KIRKLEES METROPOLITAN COUNCIL INVESTMENT & REGENERATION SERVICE

DELEGATED DECISION TO DETERMINE APPLICATIONS FOR LISTED BUILDING CONSENT

Reference No:	2024/44/92145/E
Site Address:	Railway Viaduct MDL1/27, Union Mill, Mill Lane/Grange Road, Batley
Description:	Discharge conditions 3 (OLE brackets), 4 (mortar specification), 5 (masonry repairs) on previous permission 2022/90276 for Listed Building Consent for installation of four overhead electric line equipment portals on piers 3, 7, 11 & 15 with supporting wall brackets
Recommending Officer:	Louise Bearcroft

DECISION – CONSENT GRANTED FOR DISCHARGE OF CONDITIONS 3, 4 & 5

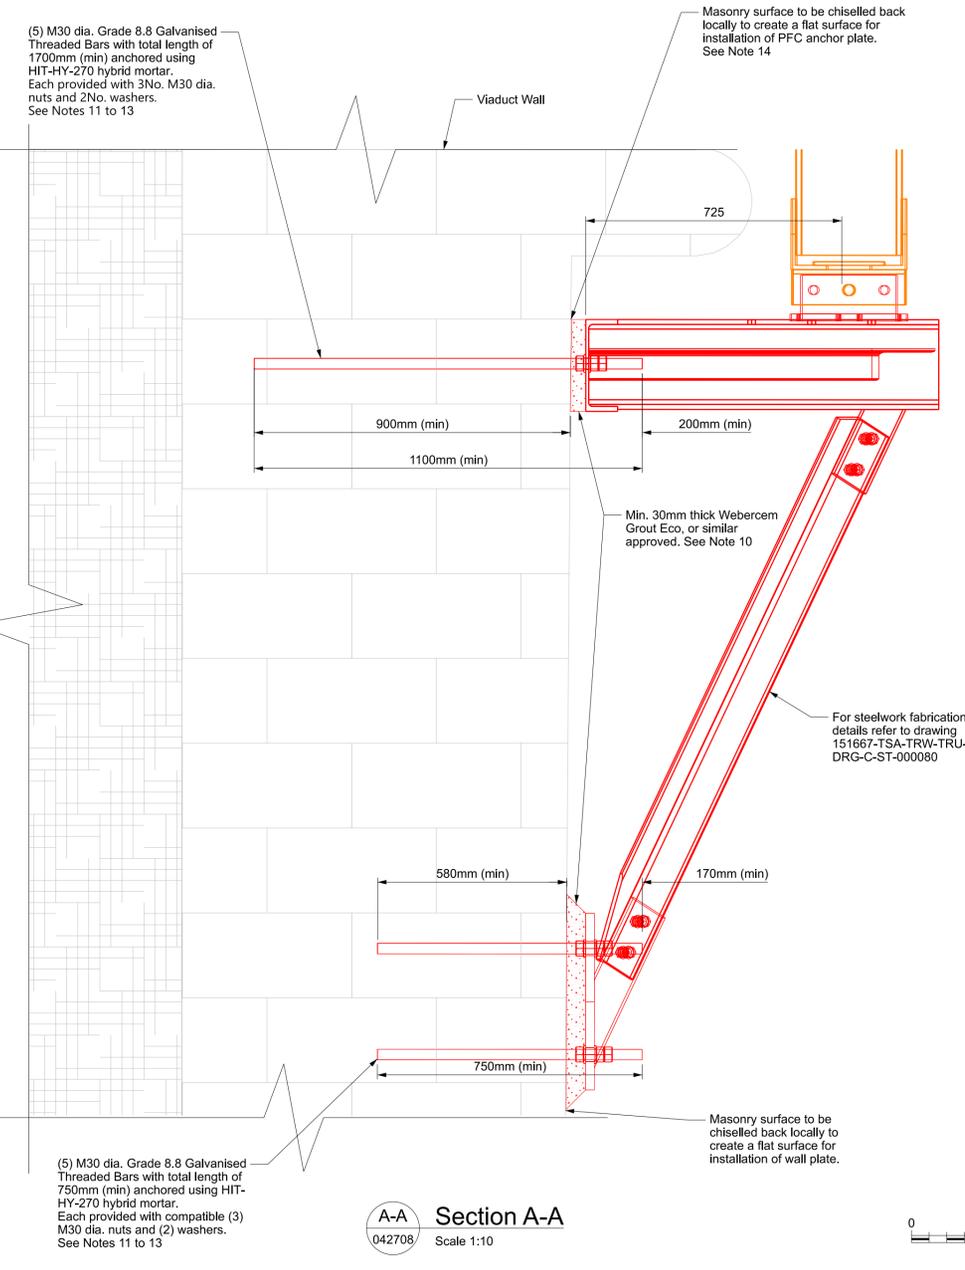
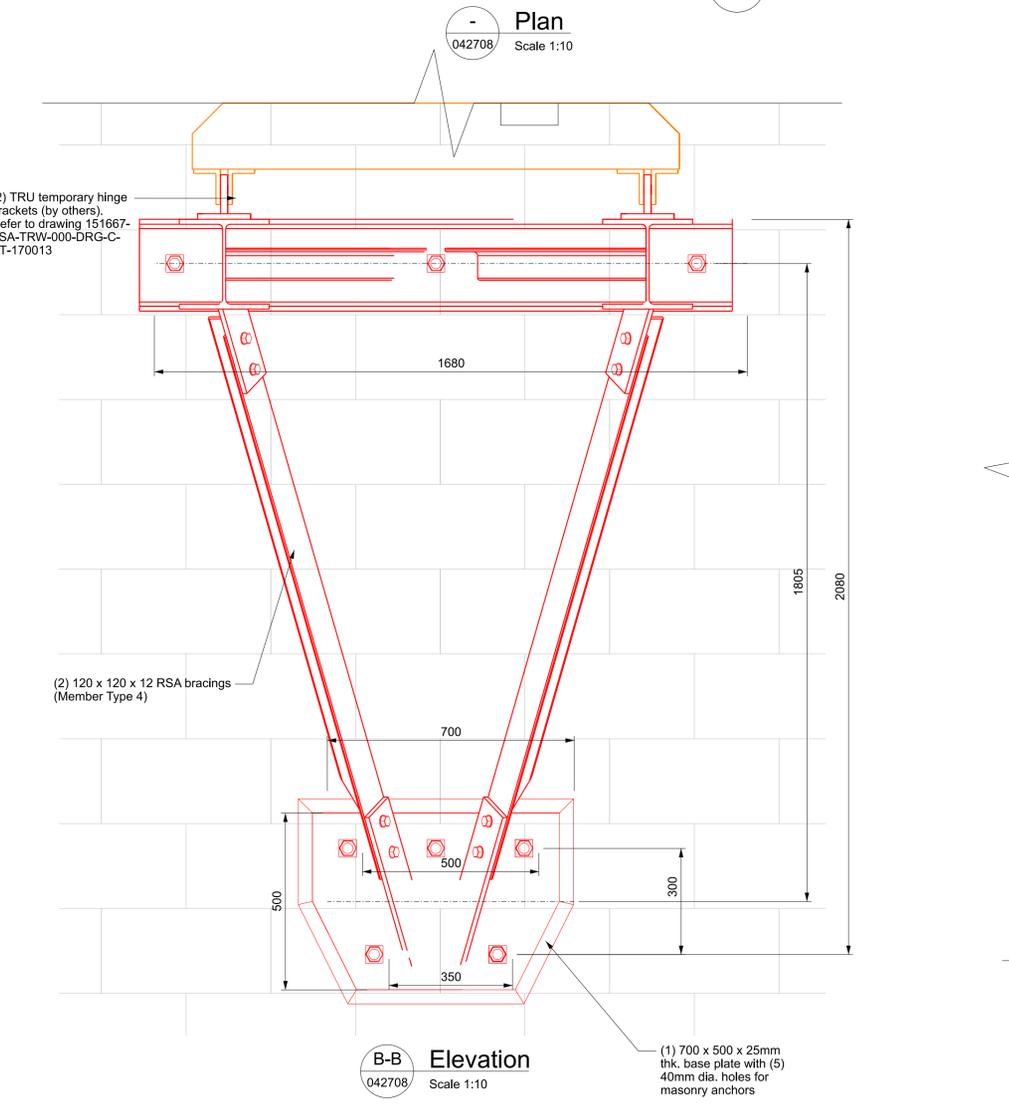
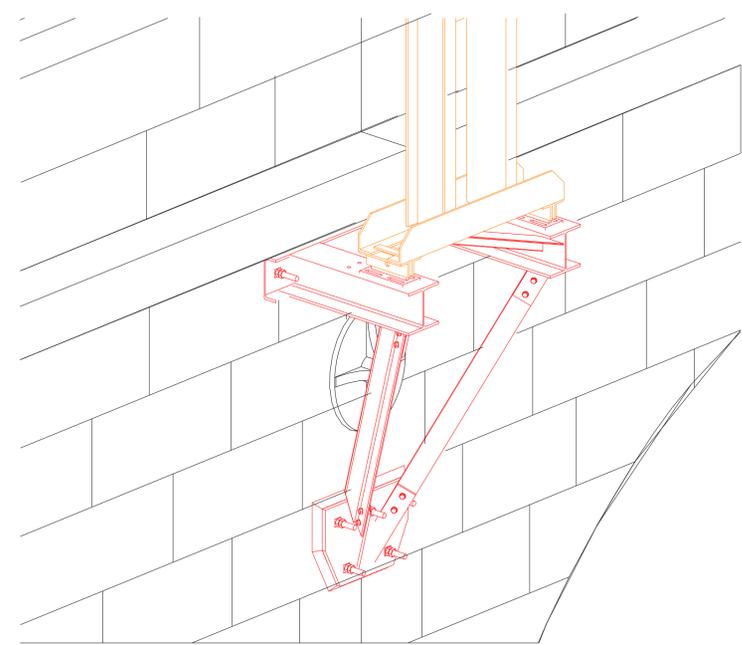
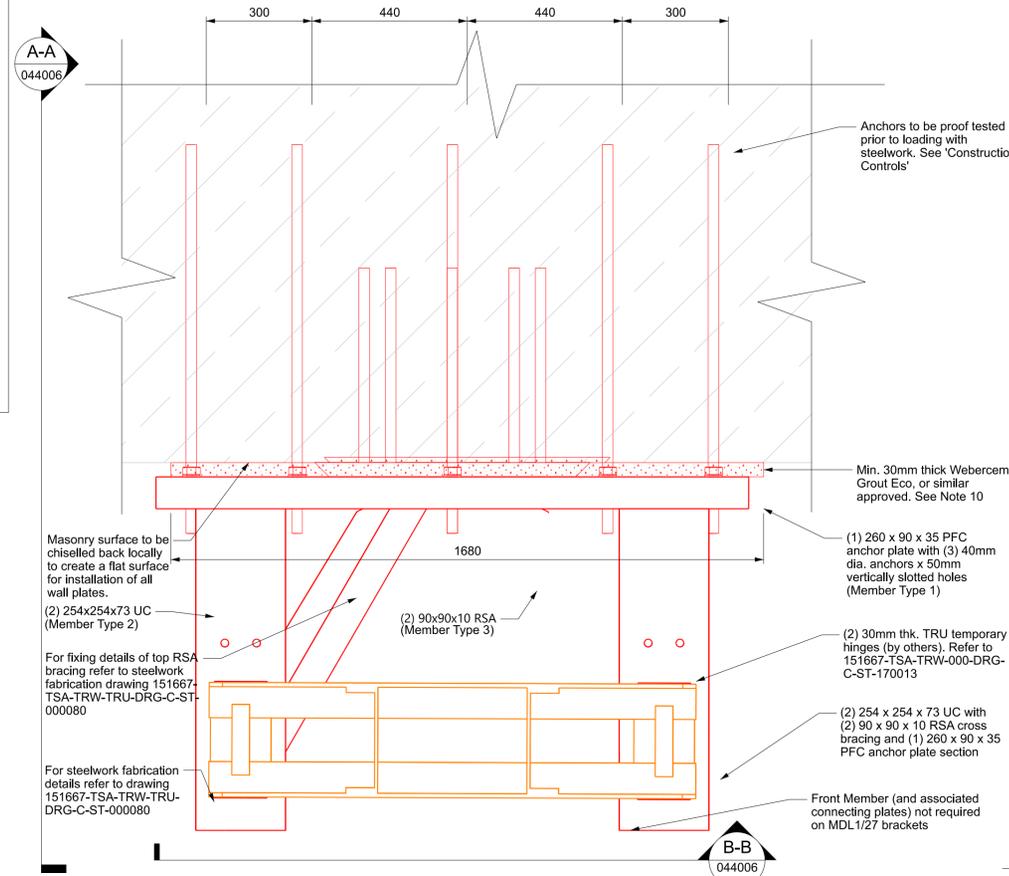
We note that with the brackets there will be a need for areas of the stonework to be flattened off to create the required surface for the bracket plate. We note that this is either to be done using hand tools or if considered necessary to be undertaken using rotary tools. This is accepted as necessary however, care should be taken to ensure that the area affected is kept to the absolute minimum and that no additional harm is incurred to the surrounding stonework. The use of cold chisels may incur greater damage to the stonework and surrounding stonework, and we would advise that their use is entirely avoided. Precision chisels should be used if undertaken by hand.

We also acknowledge that Webercem Grout Eco is to be used. We understand why this is specified for use as opposed to lime, however, we have some concerns about the long-term impacts in terms of whether the grout given it is cementitious will de-bond itself from the stonework, however, we appreciate this is in addition to the bolts/ anchors.

KC Conservation and Design advise the use of cold chisels may incur greater damage to the stonework and surrounding stonework, and their use should be entirely avoided. Precision chisels should be used if undertaken by hand.
